Five Estuaries Offshore Wind Farm Response

Access to the construction site

Bentley Road Proposal

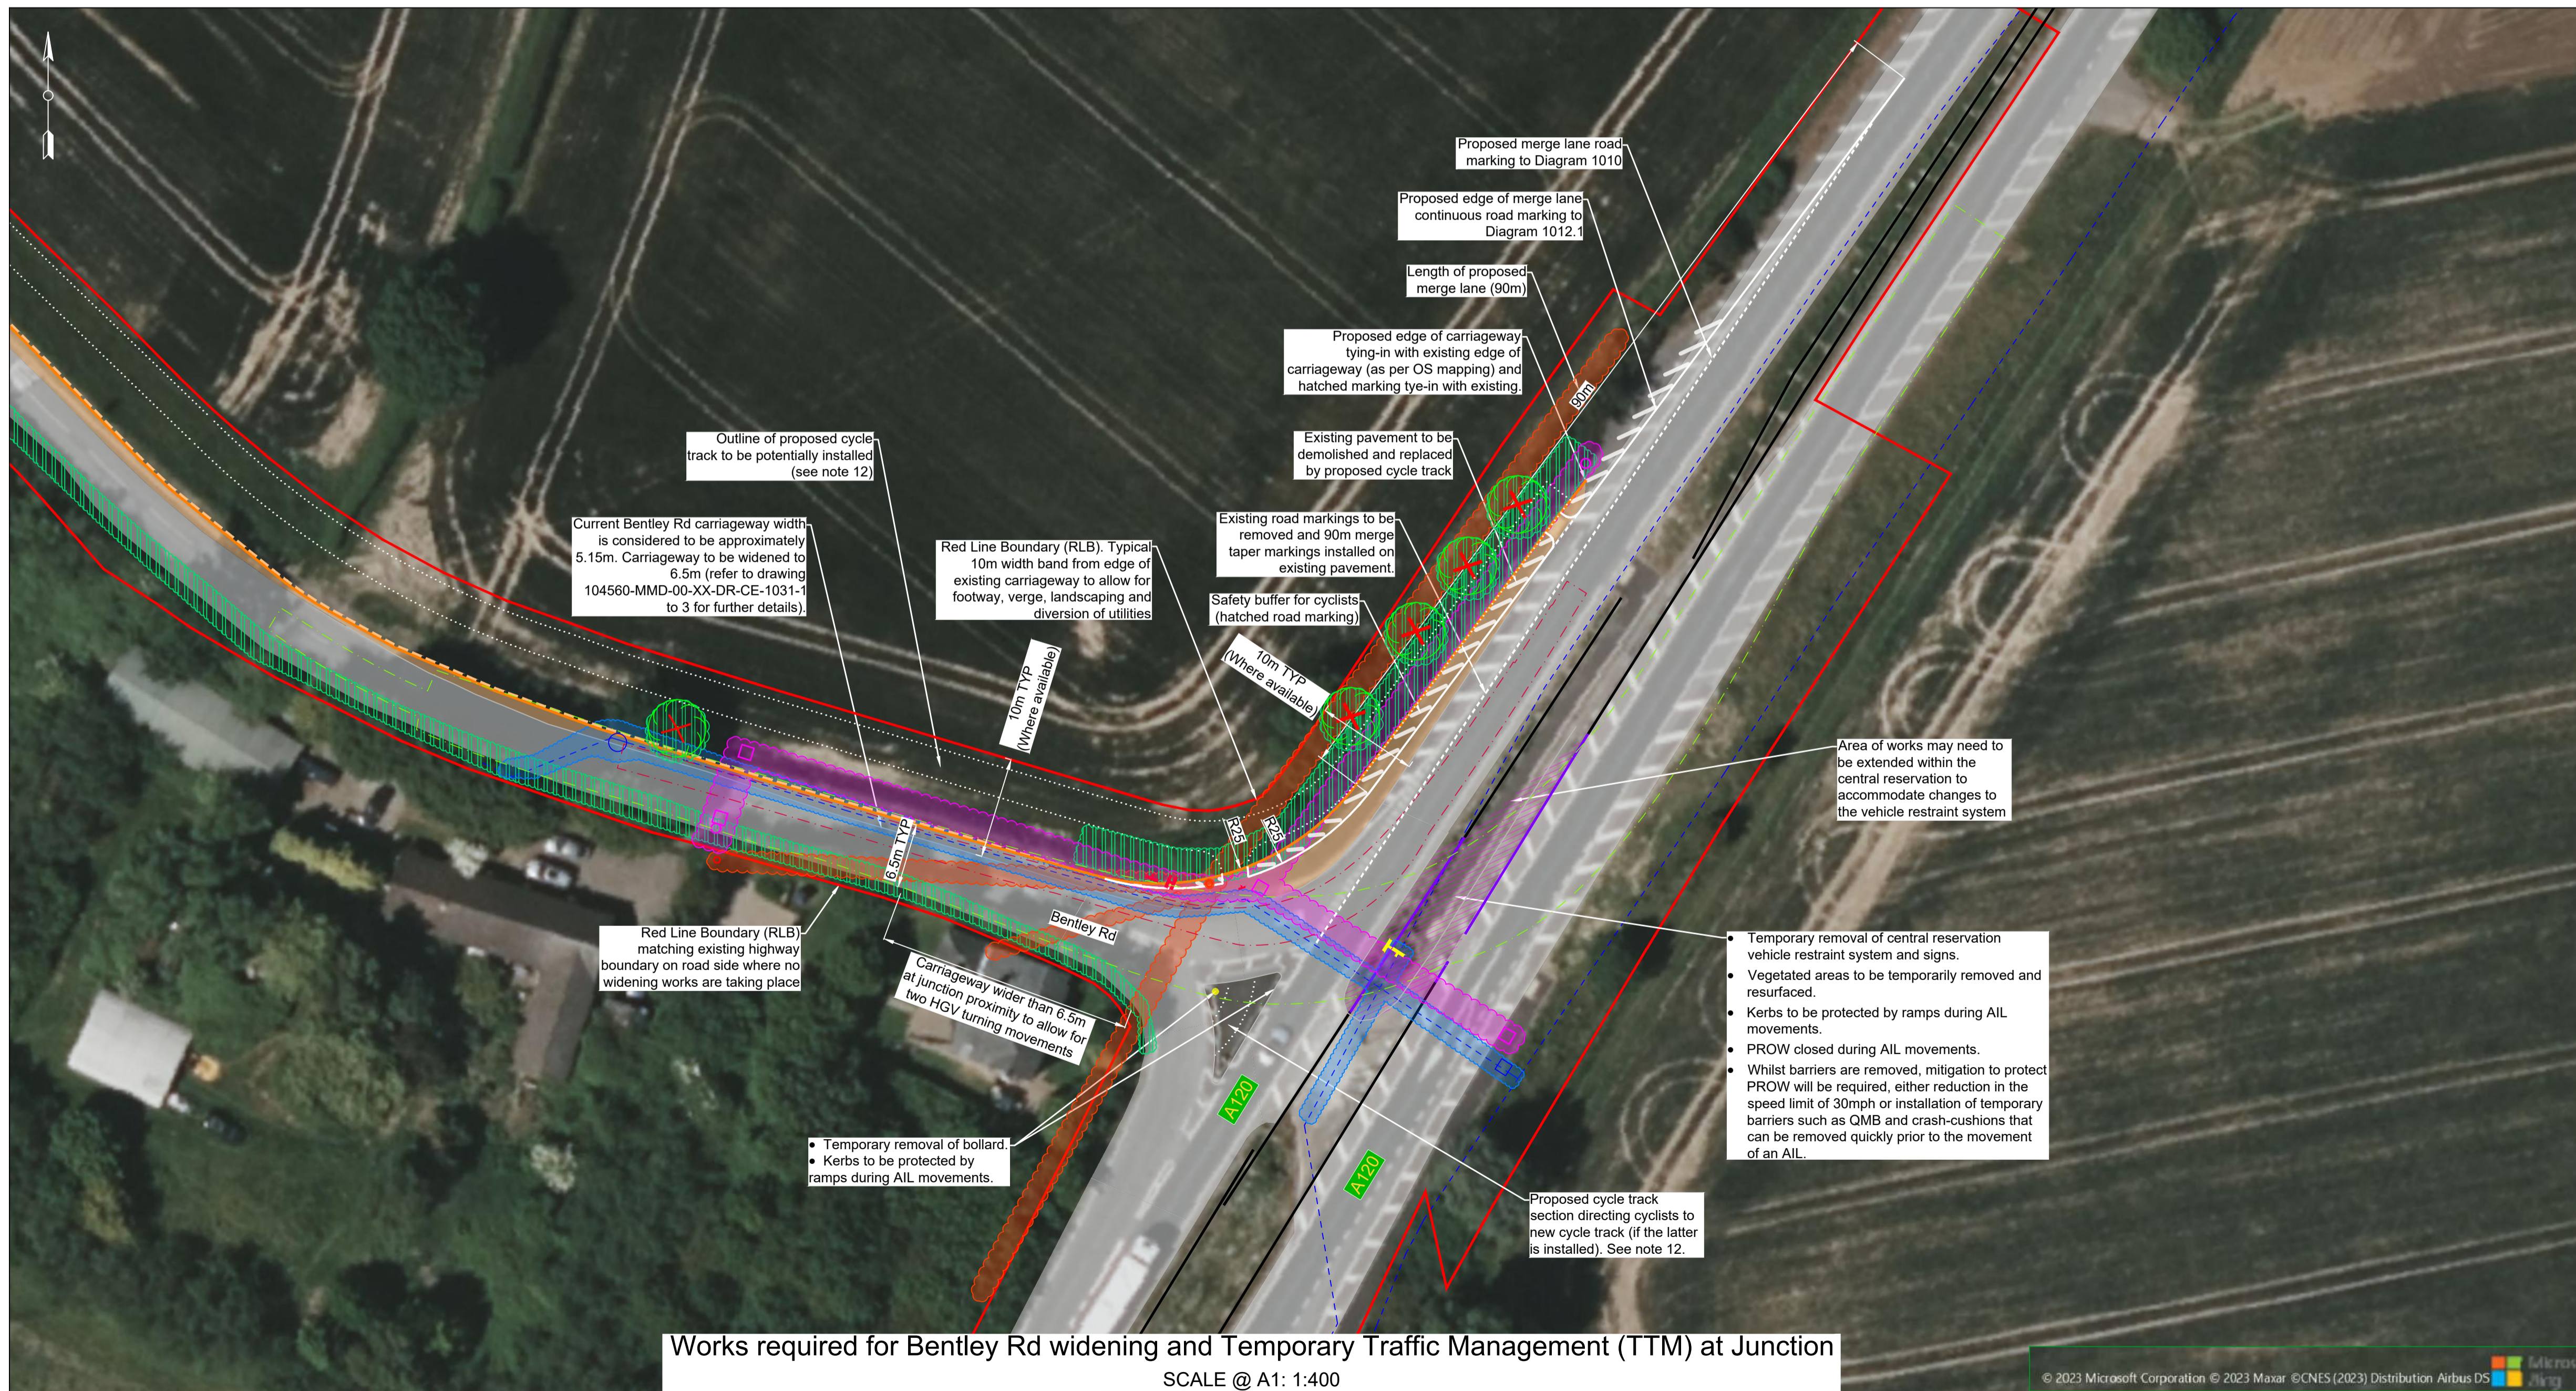
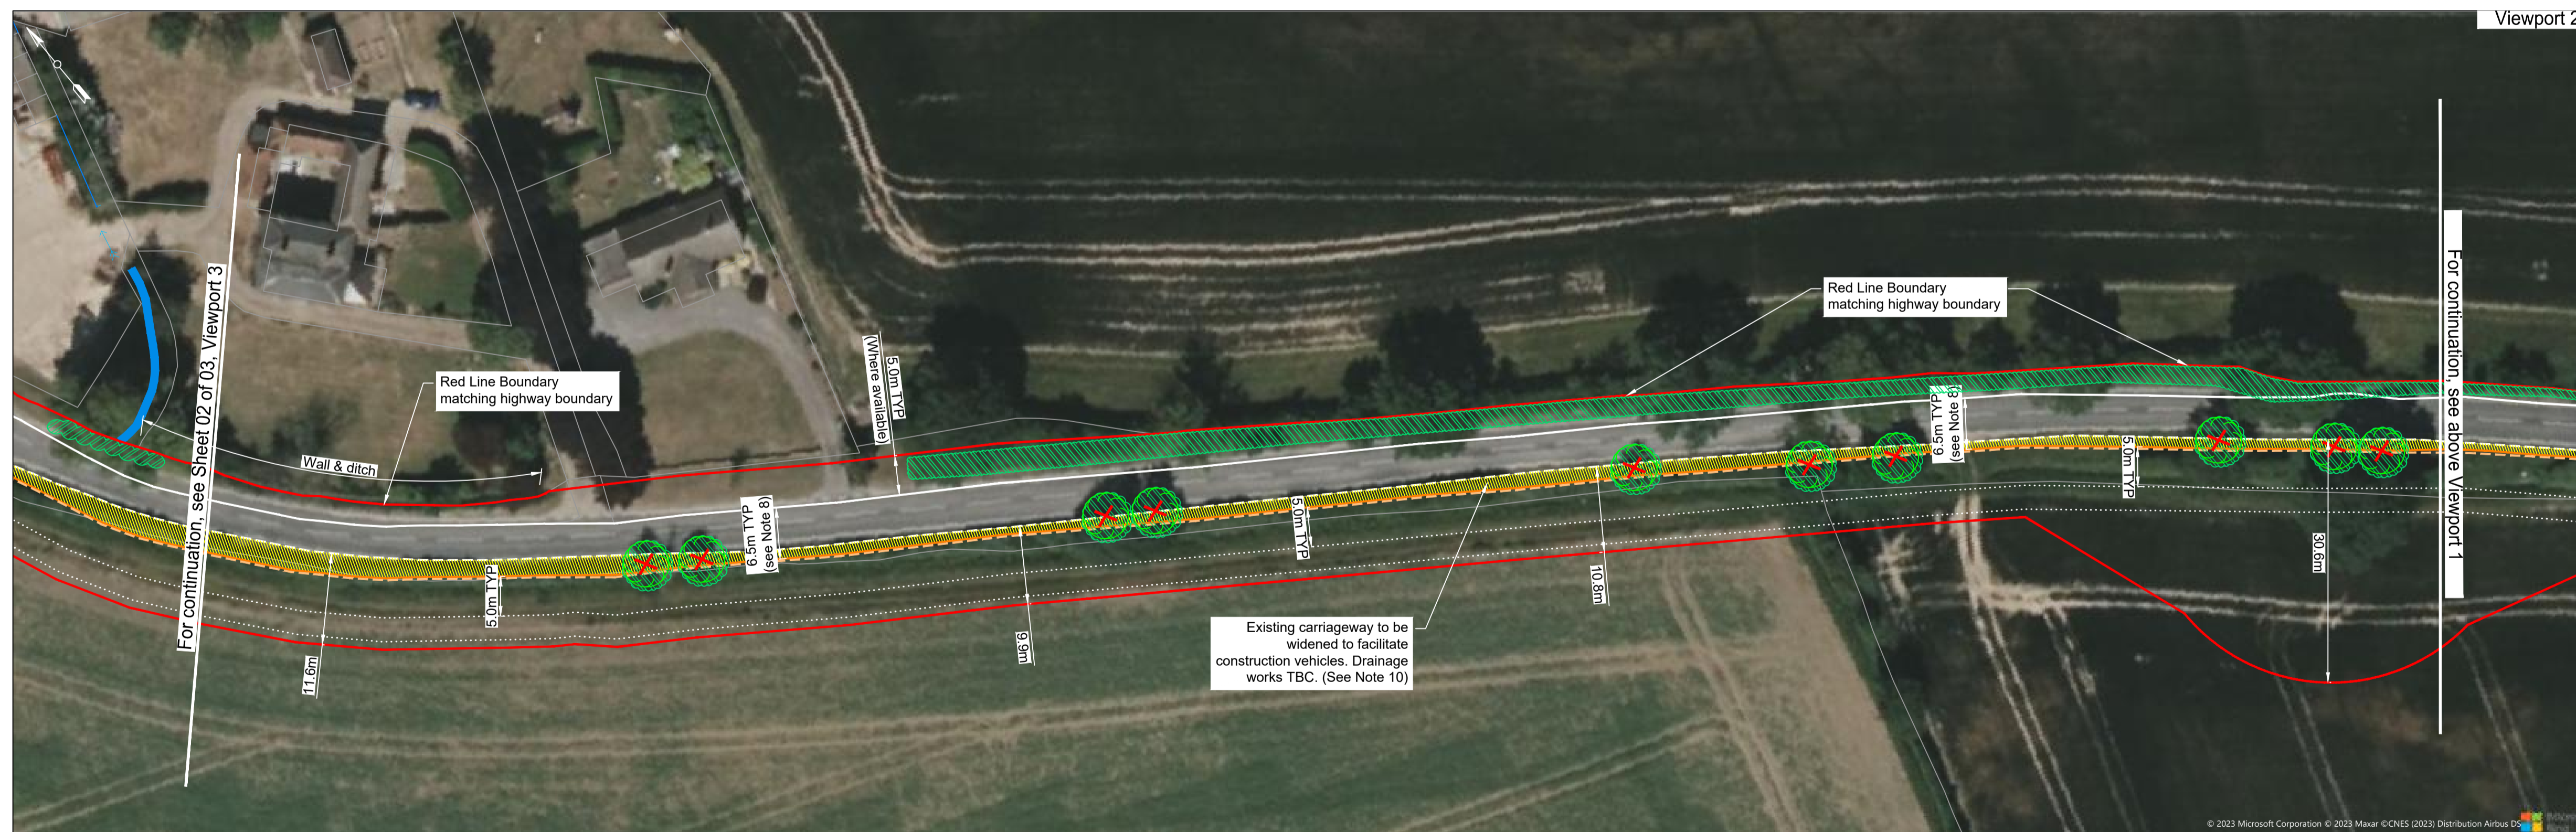
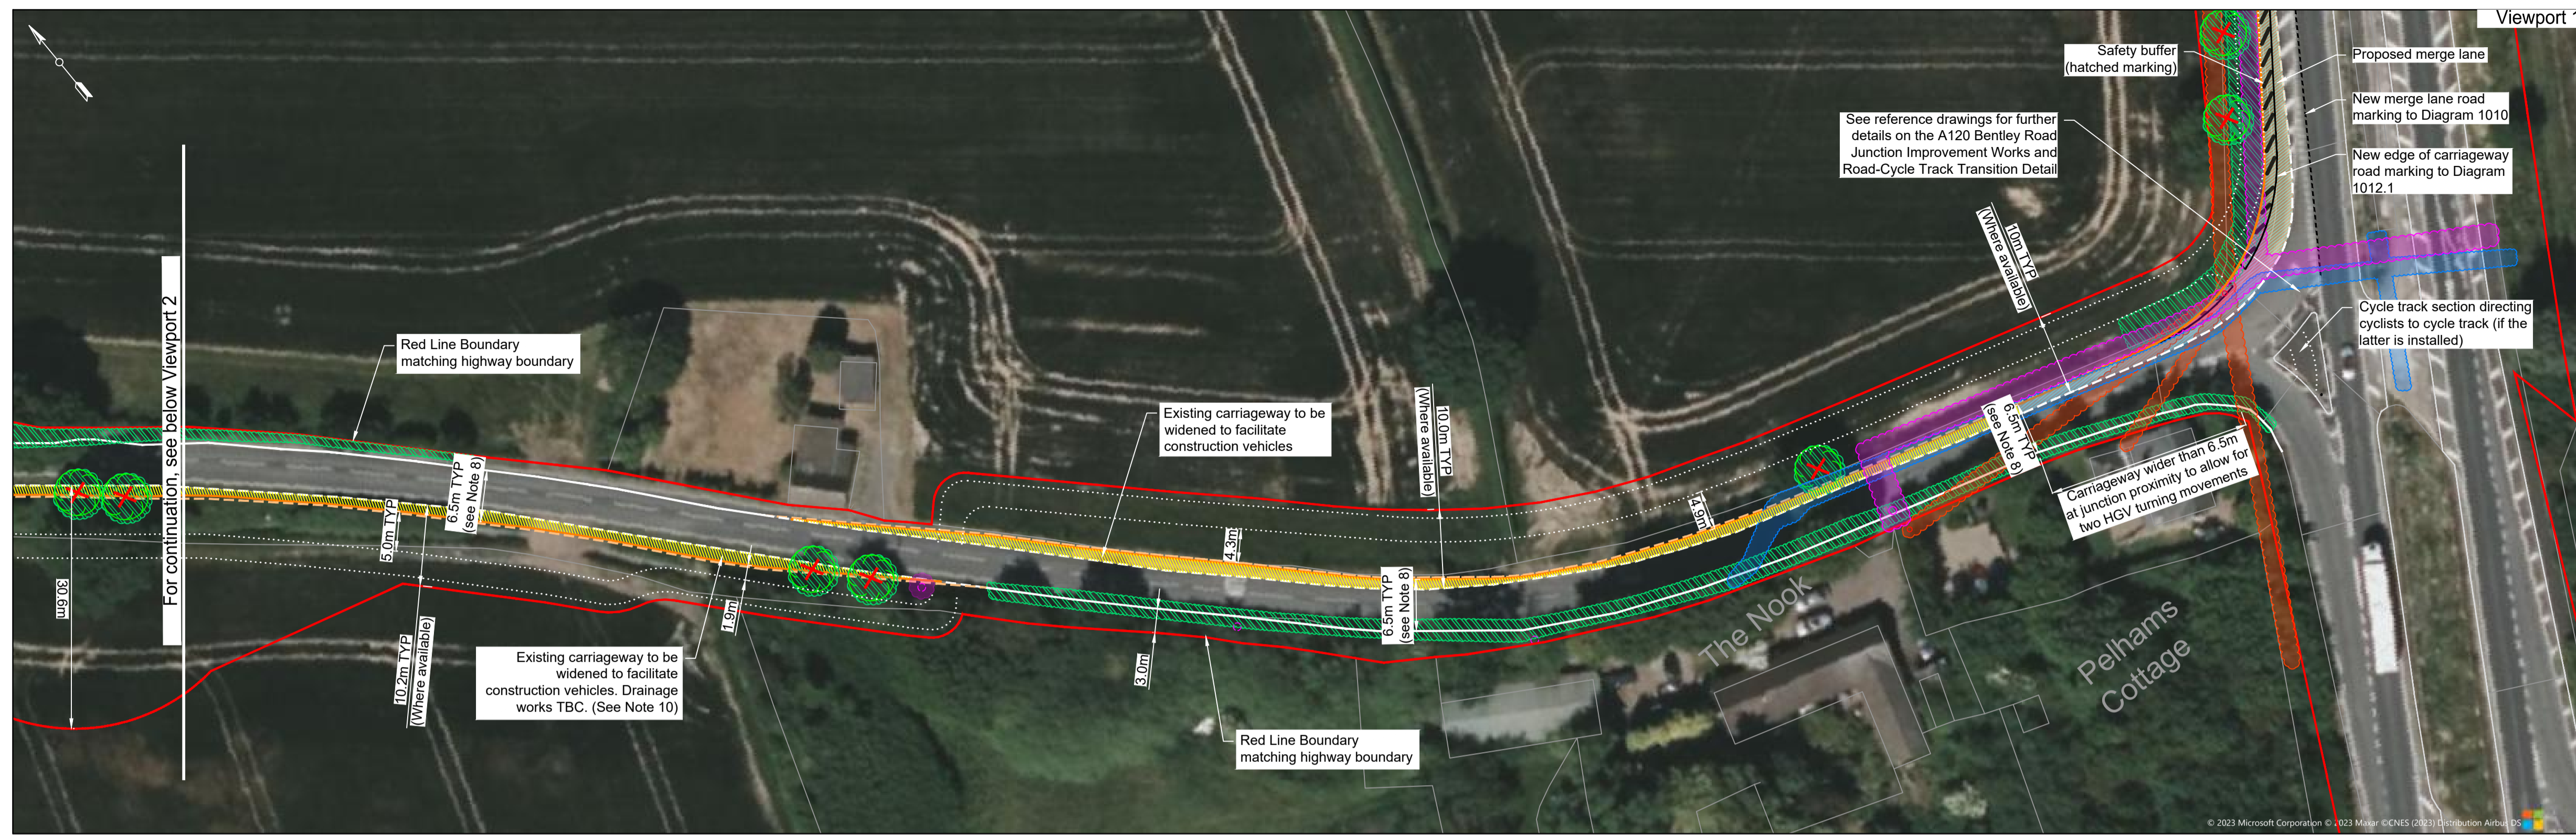
Why has there been no consideration given to a direct link from the A120 (Hare Green roundabout or Park Road) to the site? This would provide purpose-built access to the substation sites across open fields, with limited impact to residents.

Additionally, this would provide ready access for exceptional loads of plant rather than making changes to the existing A120 carriageway at Pelhams Corner.

The current Pelhams Corner layout was installed following years of campaigning to reduce the numerous fatal accidents at this site – we fear any changes to layout and/or increase in unsuitable traffic using this junction will reverse this positive impact and cause serious and fatal accidents as a result.

Given haul roads are being constructed to allow connection from Bentley road to the sub station site(s), we can see no viable reason that this could not be done directly from the A120 to the planned Haul road. Therefore requiring no changes to Bentley Road itself, the A120 junction at Pelhams Corner or the exponential increase in construction traffic on a country lane that currently sees a couple of HGVs a week.

- If insistent on using Bentley Road - move the Bentley Road Carriageway further east of our property – as far as possible but at a minimum 20-30m
 - This would create a more accessible turn – currently a very sharp turn from A120

- Moving traffic away from our boundary would reduce impact of noise/vibration/dust/pollution etc.
- Reduce construction traffic operational hours
 - Reduce to 08.00 – 18.00 Mon-Fri – Therefore the worst impact will be felt during the working day, allowing us some peace outside these times

- Install a grass verge between our home and the new Bentley Road carriageway
 - Install bollards to restrict parking/mounting the verge and improve our safety from passing HGVs

- Install noise reduction methods - fencing / trees / shrubs
- Install a path so we may use the roadway other than in a vehicle
 - Install this on the residential side of the road
